RE: Application for Fill Permit, 42 Huntington Avenue
(ID # 2004-0248) (CBL# 410C001)

On December 6, 2004, the Portland Planning Authority granted approval for a fill permit at 42 Huntington Avenue, with the following conditions:

Drawing Name: **Lot 17 Grading Plan**
Project: **PRESUMPSCOT RIVER PLACE**

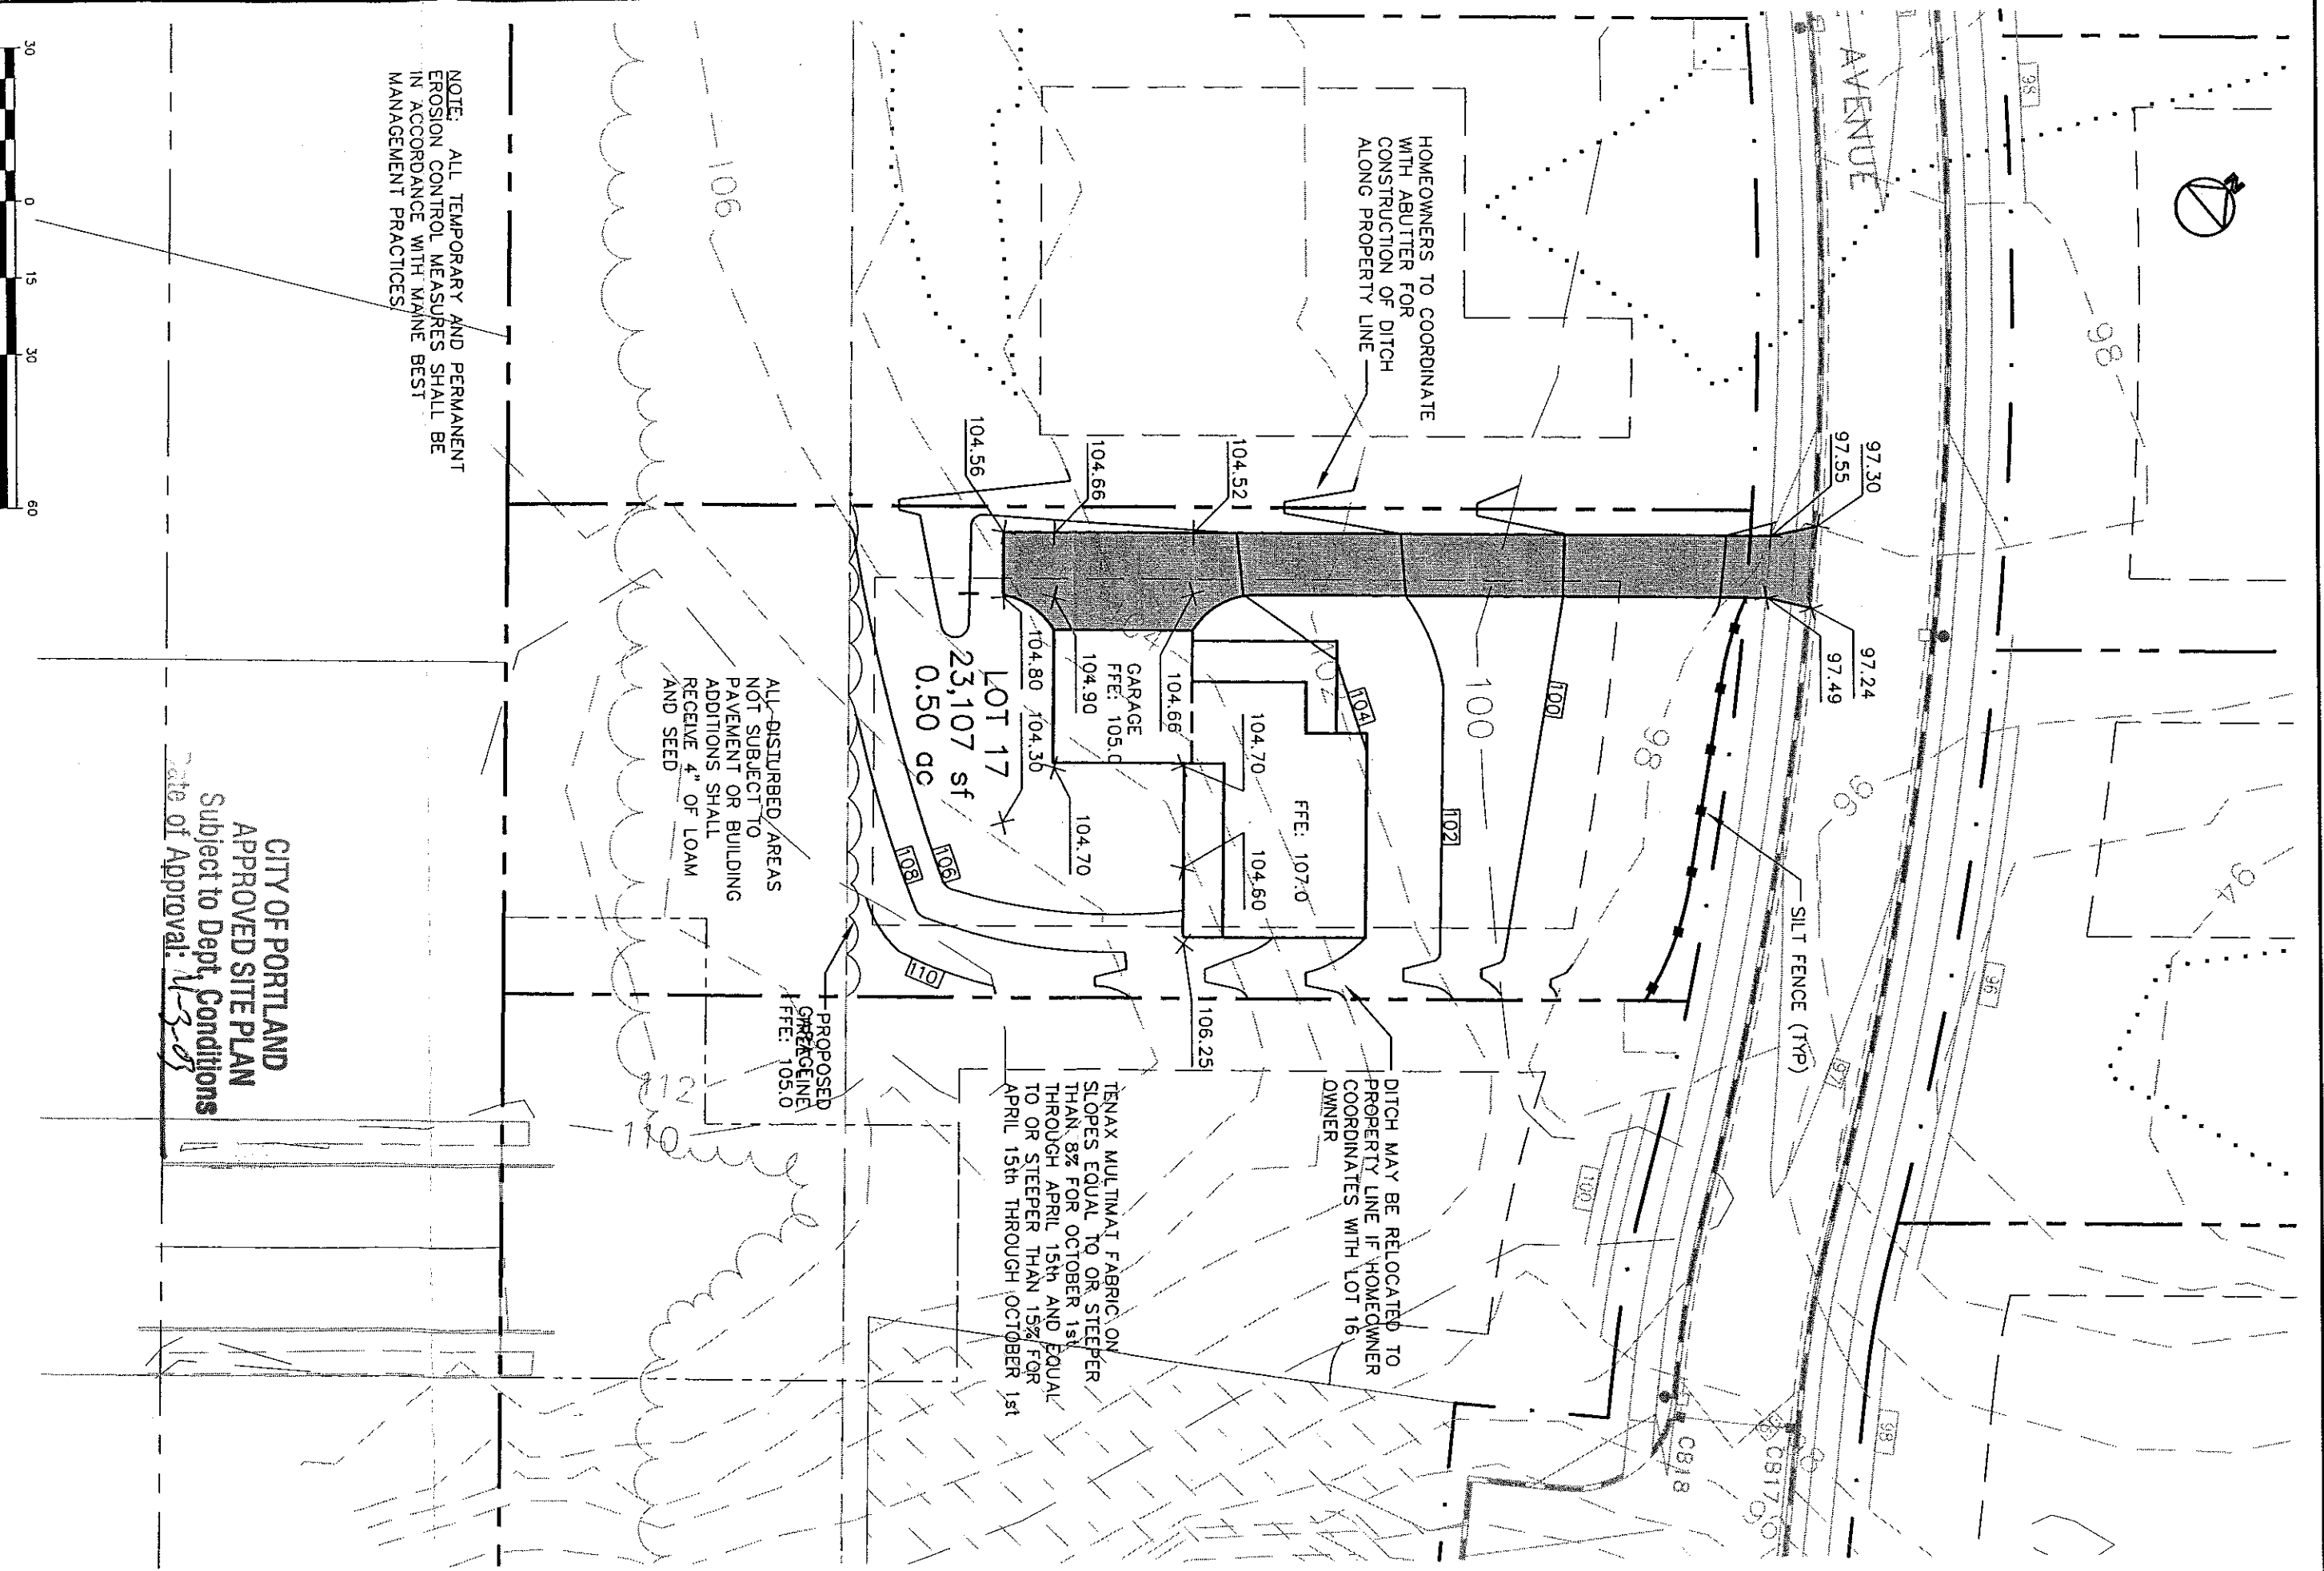
1. *The connection to the City installed field inlet shall be done with a 'Nylosplast drop in grate' (See detail attached), or approved equal.*
